SHEET NAME
PRELIMINARY PLAN - SOUTH SITE
PROJECT NAME
RIVERBEND RESIDENTIAL DEVELOPMENT
5680 US HIGHWAY 87-95
COLORADO SPRINGS, CO 80904

SHEET NUMBER
S-2
2 OF 3 SHEETS
COUNTY FILE NUMBER:
PCD File No. SF187

RIVERBEND RESIDENTIAL
DEVELOPMENT

SHEET NUMBER  
S-1  
1 OF 3 SHEETS  
COUNTY FILE NUMBER:  
PCD File No. SP187

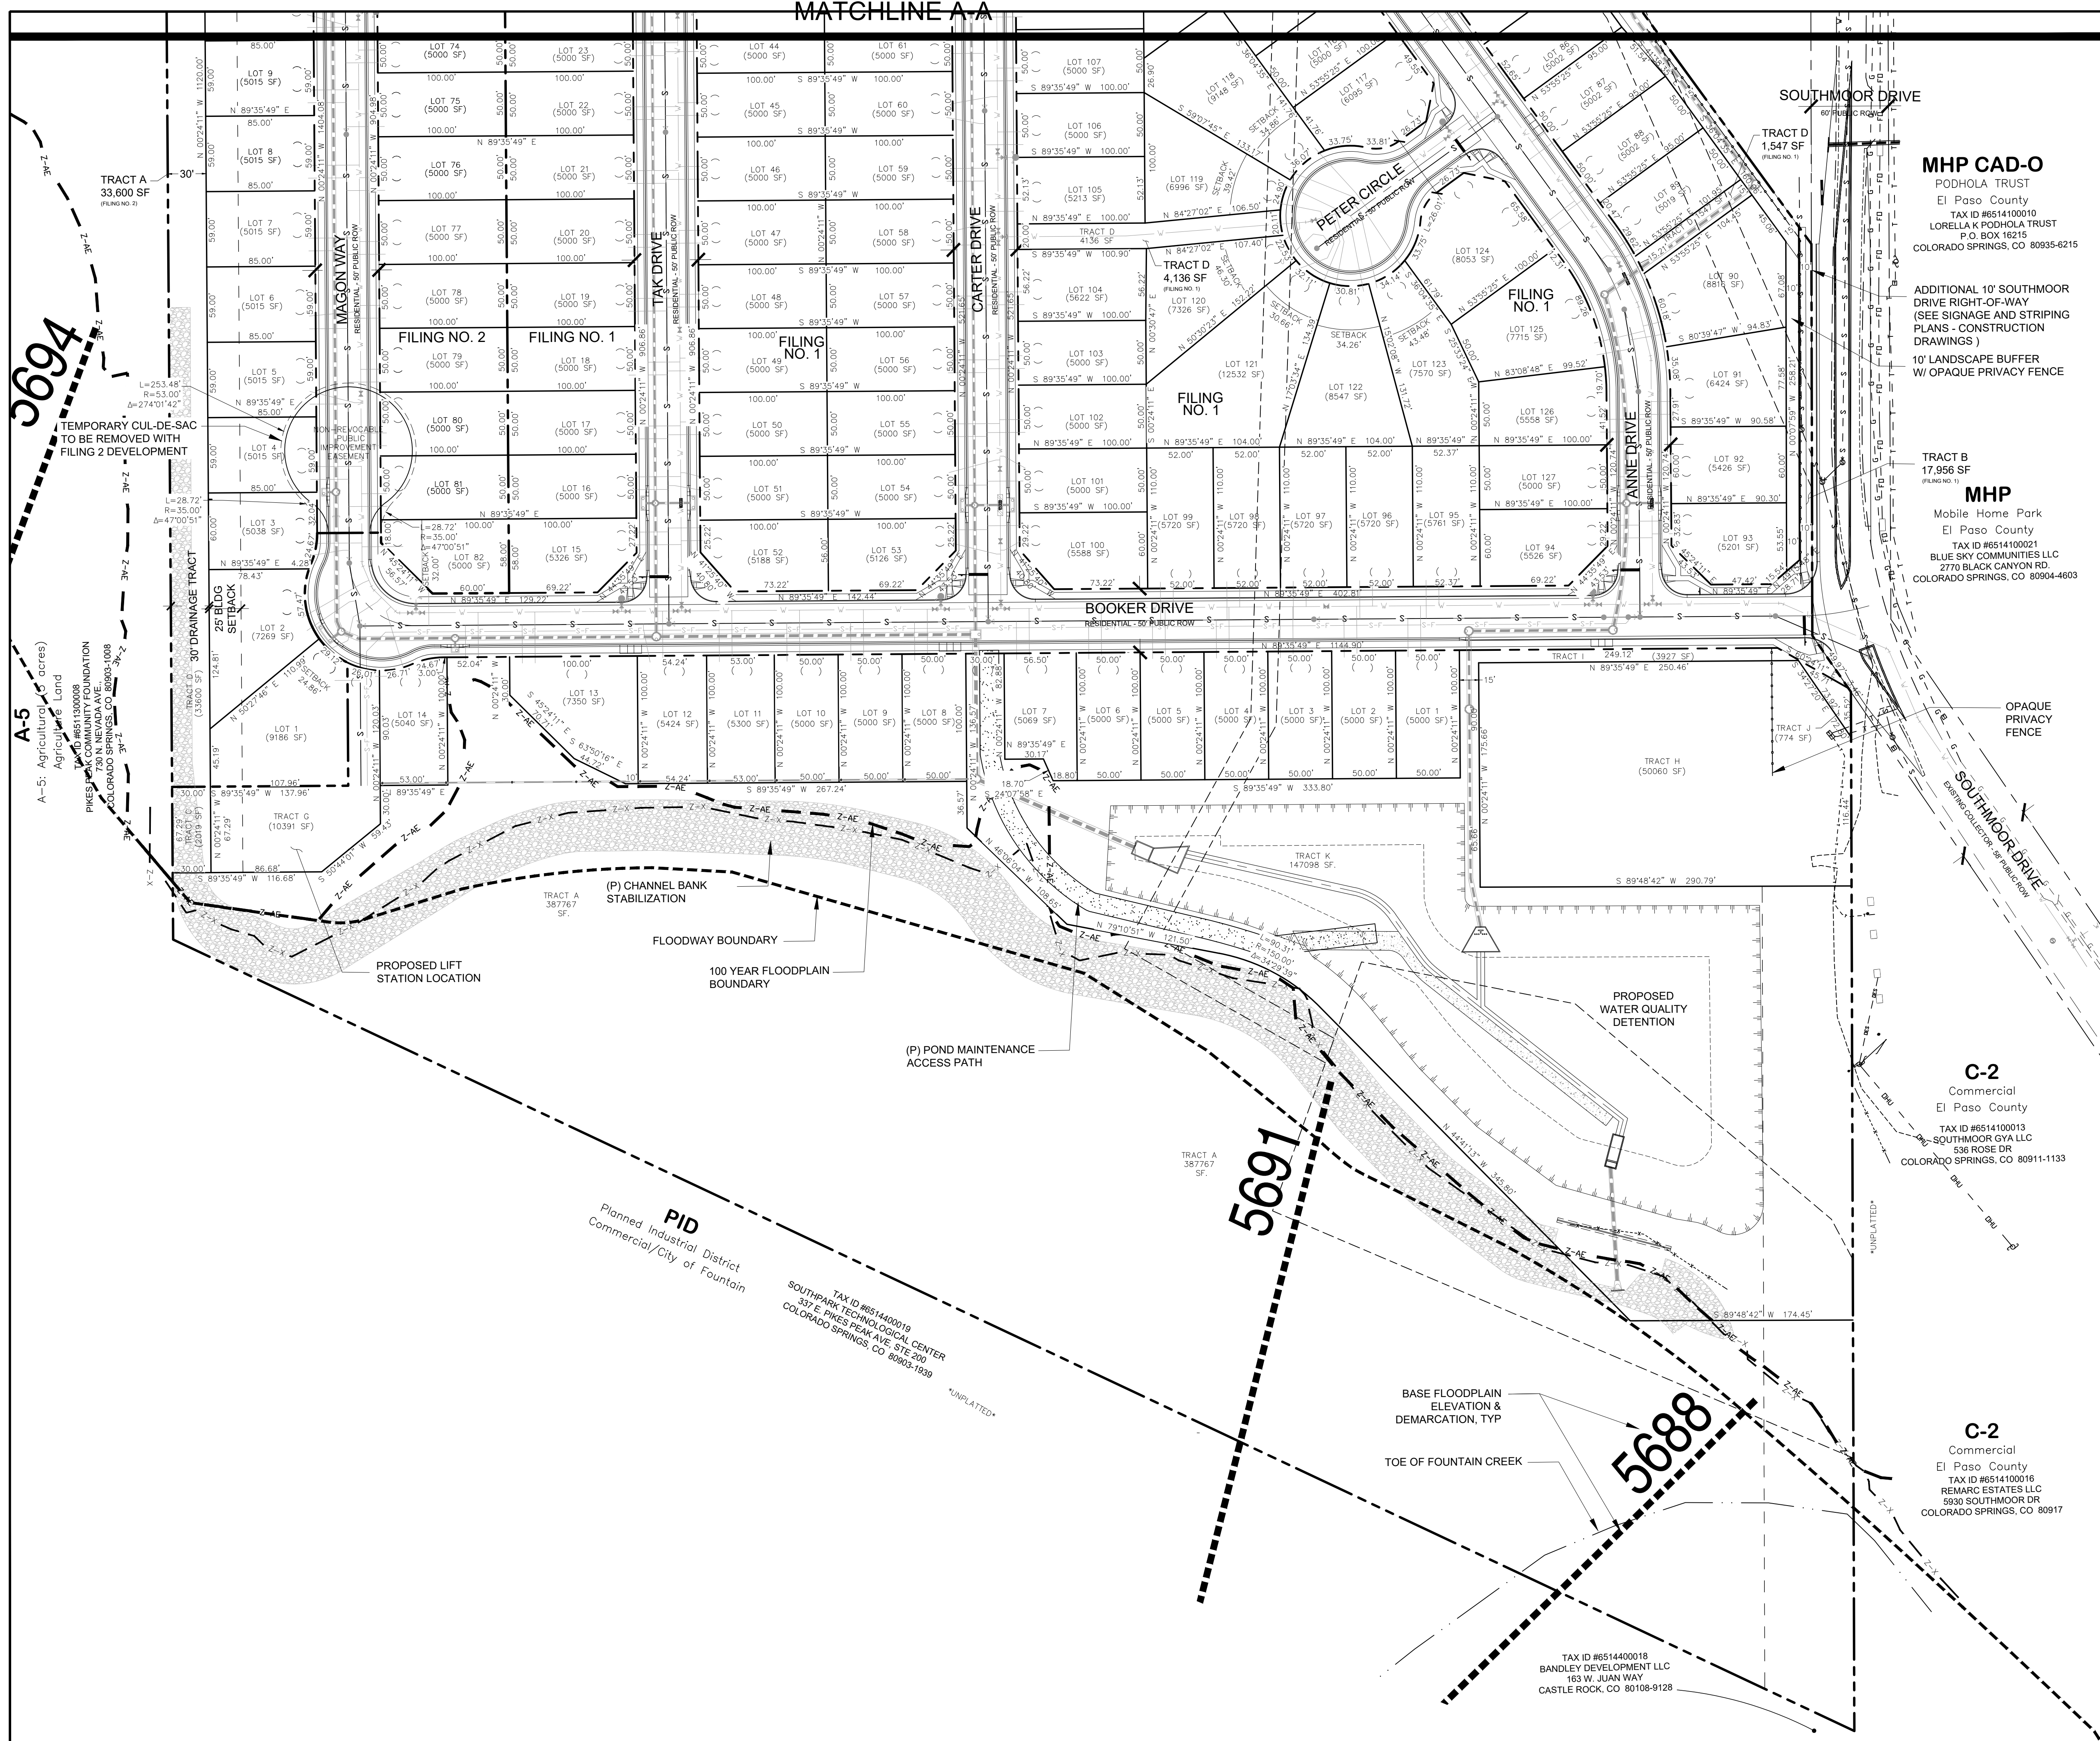
General Comment: most lots are right at the 5000 sq ft min lot size. This does not allow for much flexibility when building with the setback requirements. Please verify that homes of differing types, as well as future improvements (decks, patio covers, gazebo, etc.) can reasonably be accommodated.

**S-2**

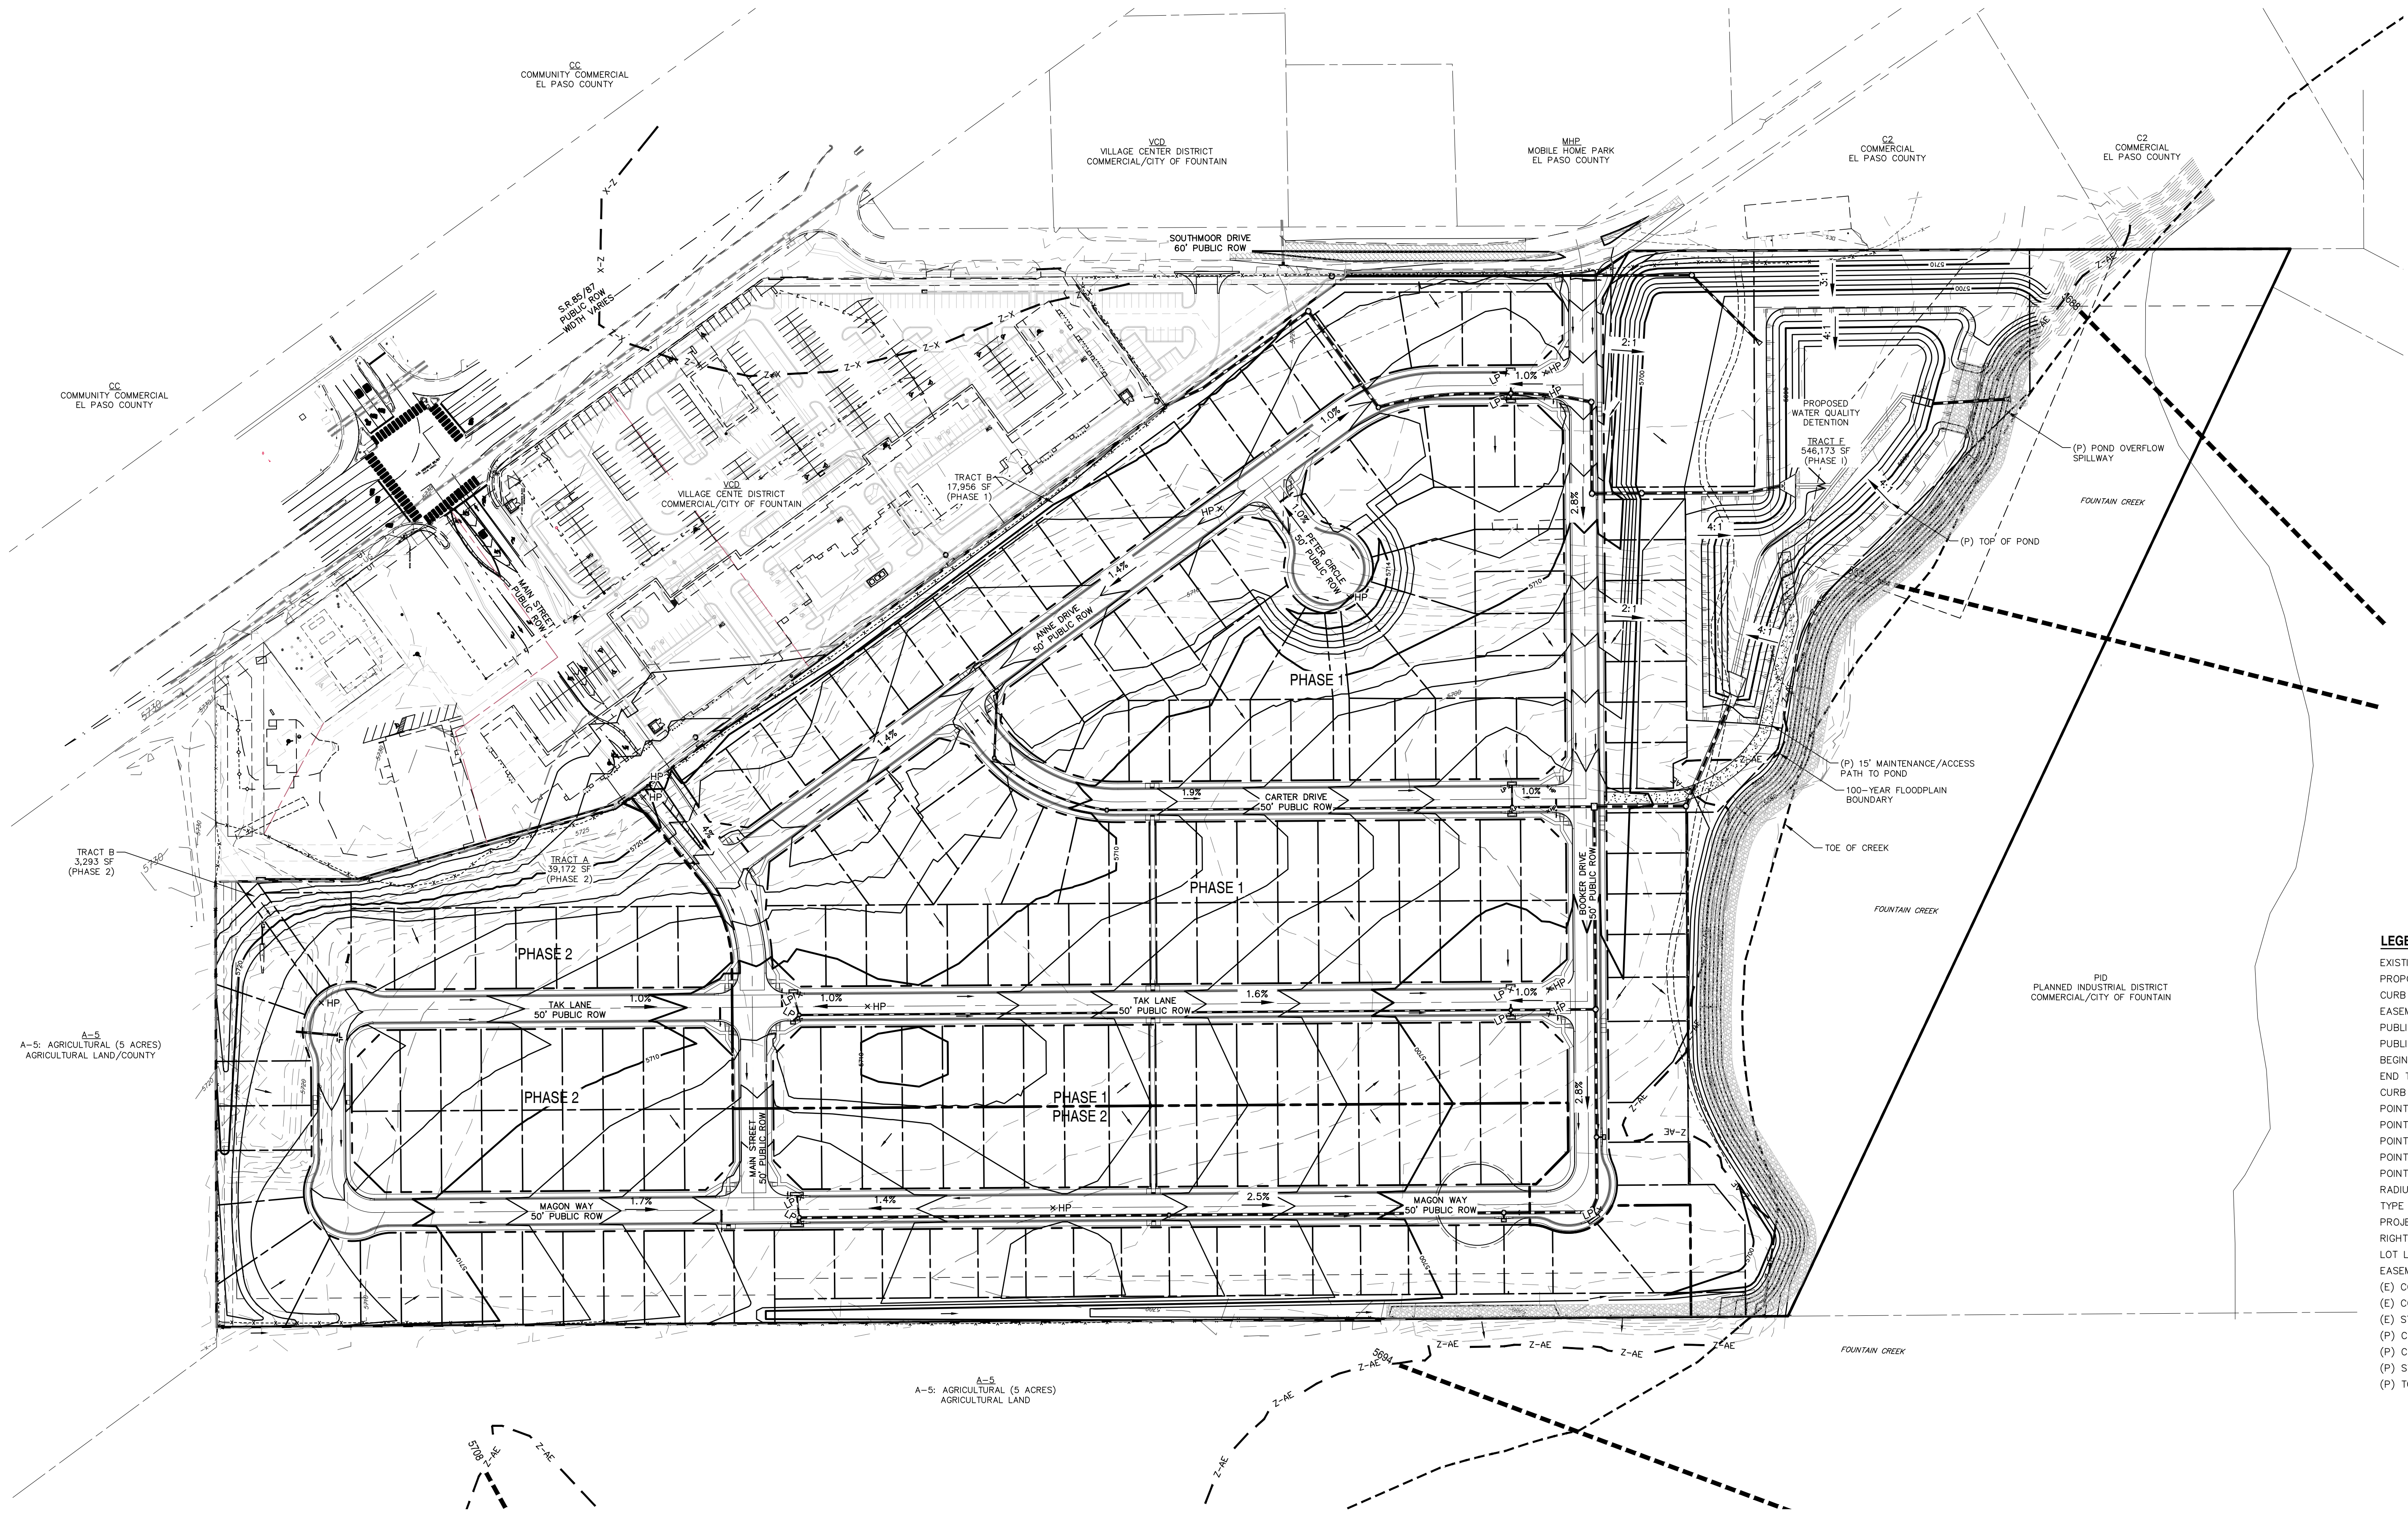
- Show the existing & proposed offsite striping along Southmoor Drive.
- Provide typical cross sections along Southmoor Drive.
Unresolved.

Monument can't be in the ROW. Relocate.

Per the revised TIS (Fig 18) show the additional offsite improvement south of Booker Dr and Southmoor Dr intersection.

Based on projected 2040 total traffic volumes and the criteria contained in the El Paso County Engineering Criteria Manual (ECM), a northbound left-turn deceleration lane would not be required on Southmoor Drive approaching the proposed residential full-movement intersection. However, Figure 18 shows the recommendation to add the left-turn deceleration lane. The left-turn deceleration lane would be located south of the intersection. The left-turn deceleration lane would be located south of the intersection. The left-turn deceleration lane would be located south of the intersection.
